A46 Newark Bypass

Scheme Number: TR010065

Statement of Common Ground with Canal & River Trust

February 2025

DRAWING TITLE
 Figure 2.4
 Locations of Temporary Works Areas Required
 During Construction
 Sheet: 3 of 4

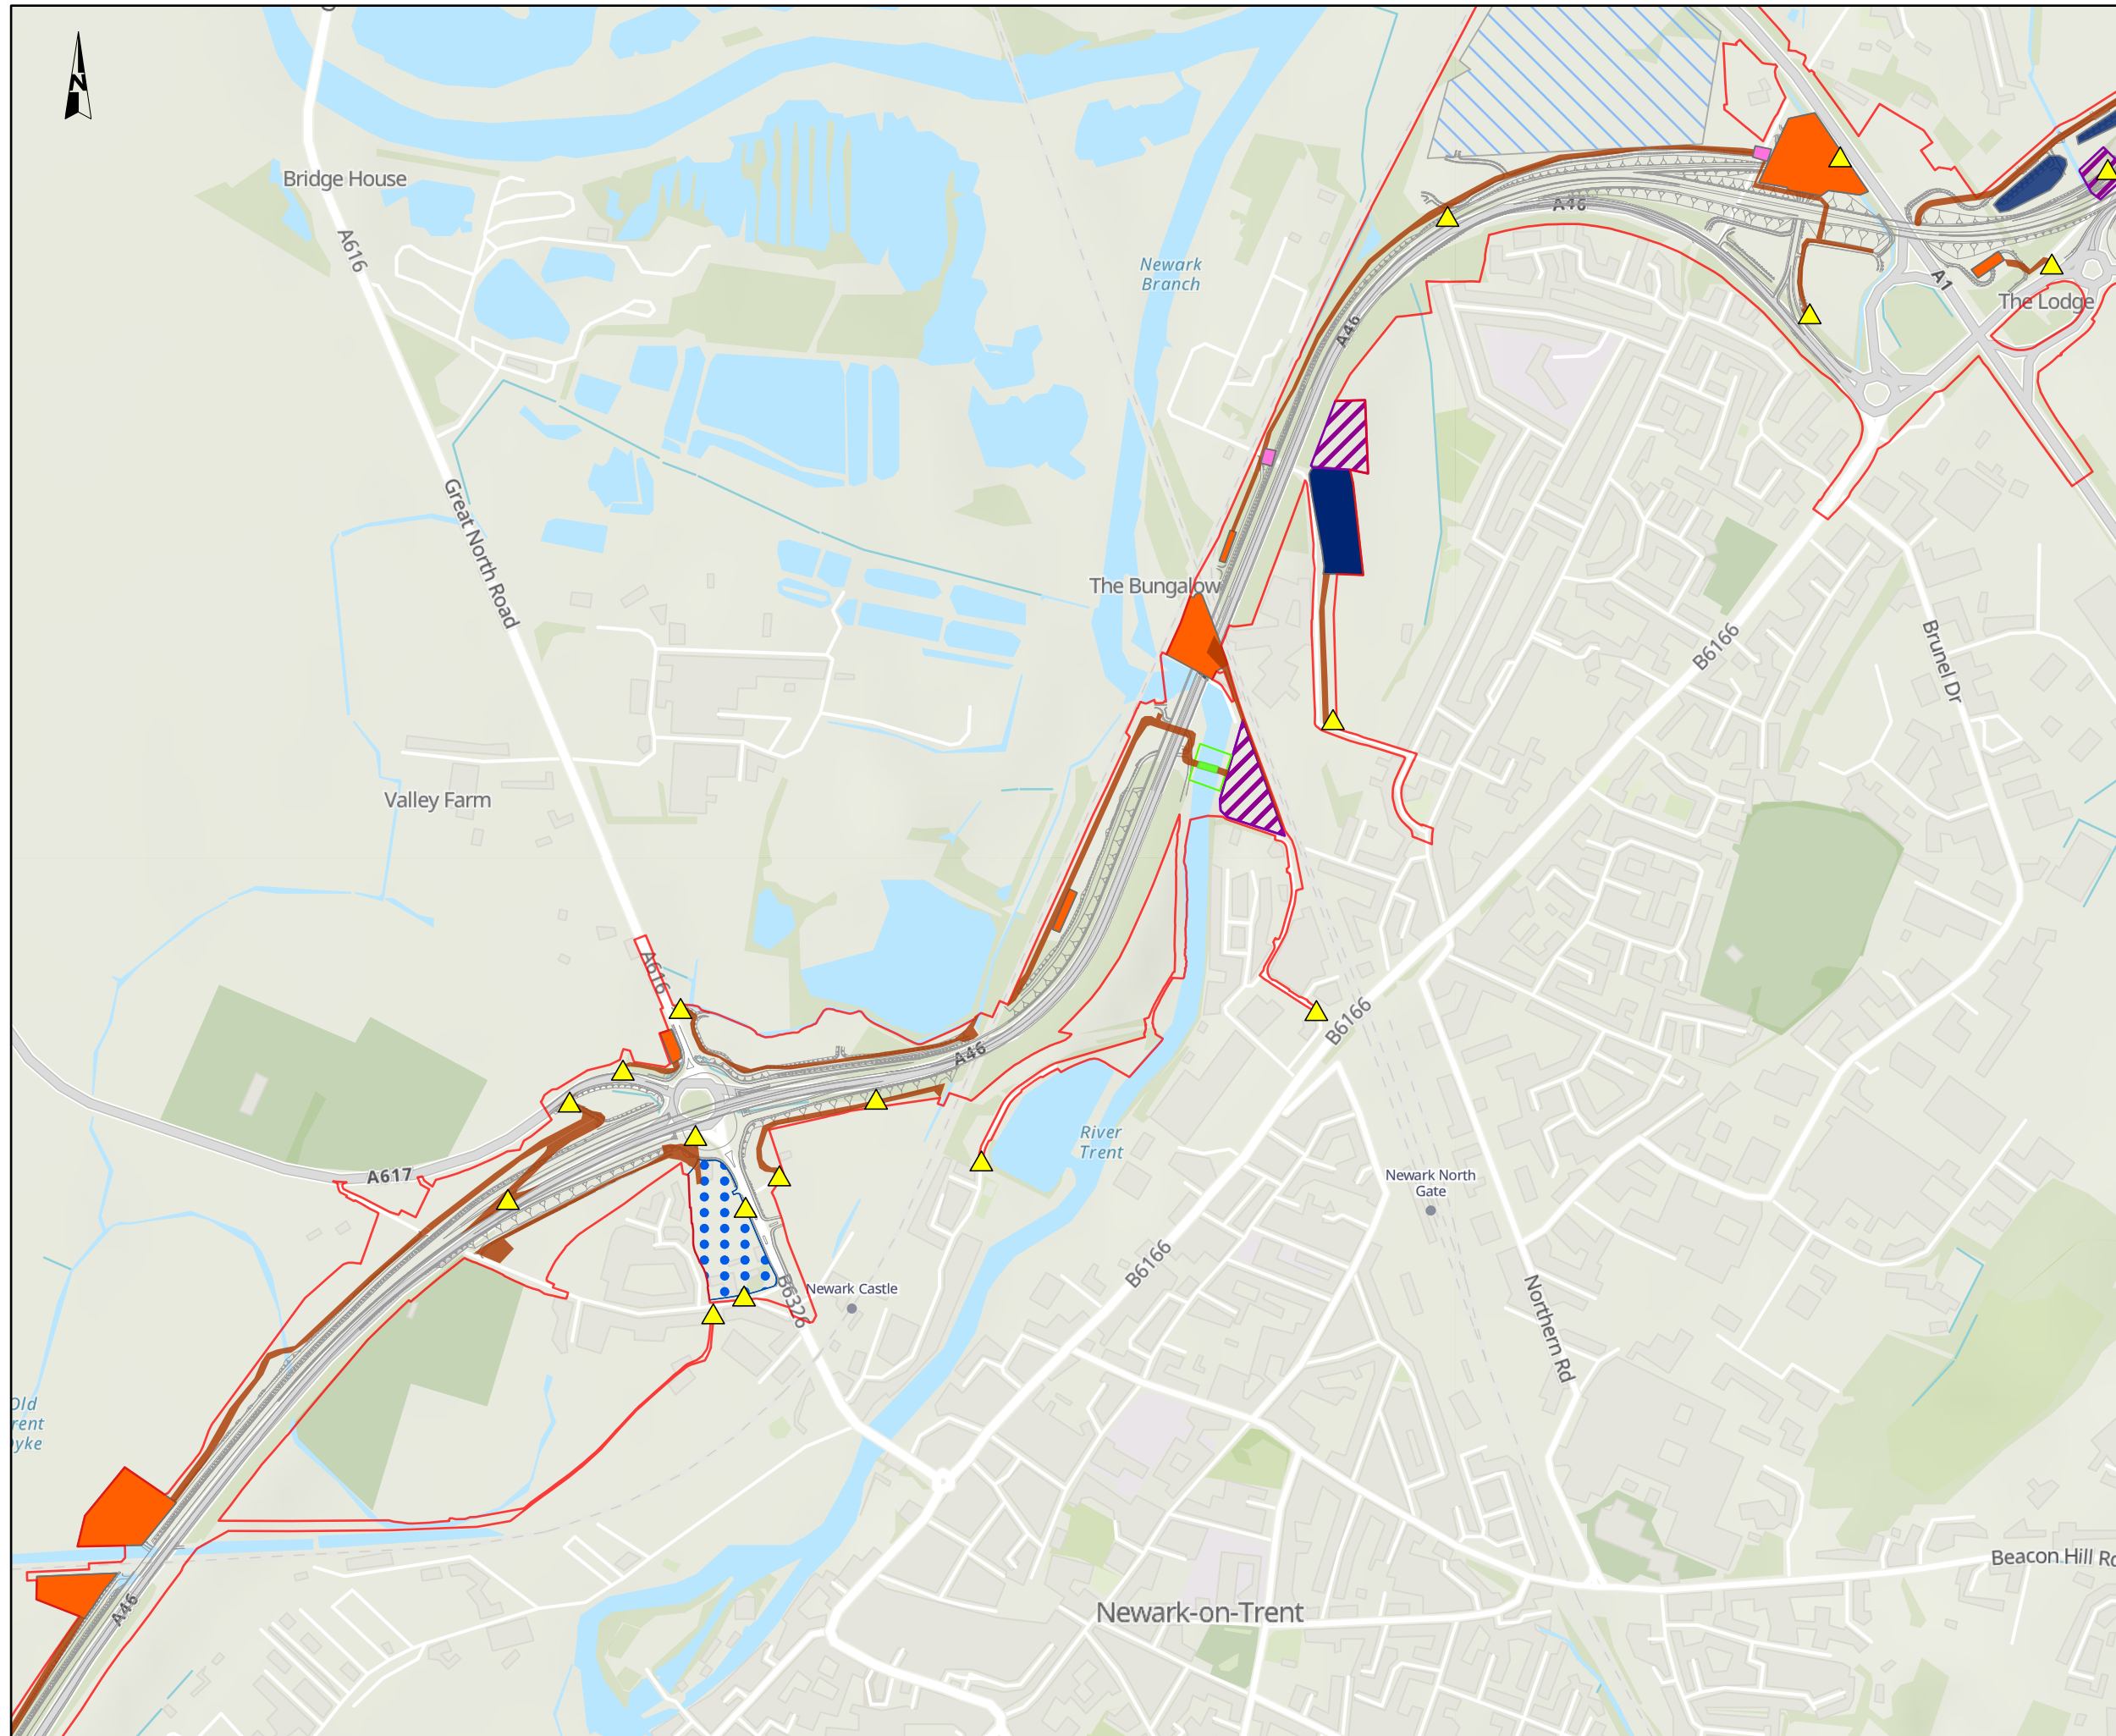
2.	Temporary Bridge Crossing of the River Trent	draft Development Consent Order [REP1-001]	<p>A temporary bridge is proposed to provide access to the work areas.</p> <p>The Trust would need to review full details of the proposed crossing to ensure that the final design will be appropriate to allow for safe boat passage below. This could be secured via Protective Provisions.</p> <p>The Trust and the applicant have agreed wording for these Provisions, which we understand are to be submitted at Deadline 5.</p>	The Applicant agrees and will provide the Approval in Principle and detailed design drawings for the temporary bridge to the Canal & River Trust for their review. This will be secured through the protective provisions.	Agreed	26/04/2024
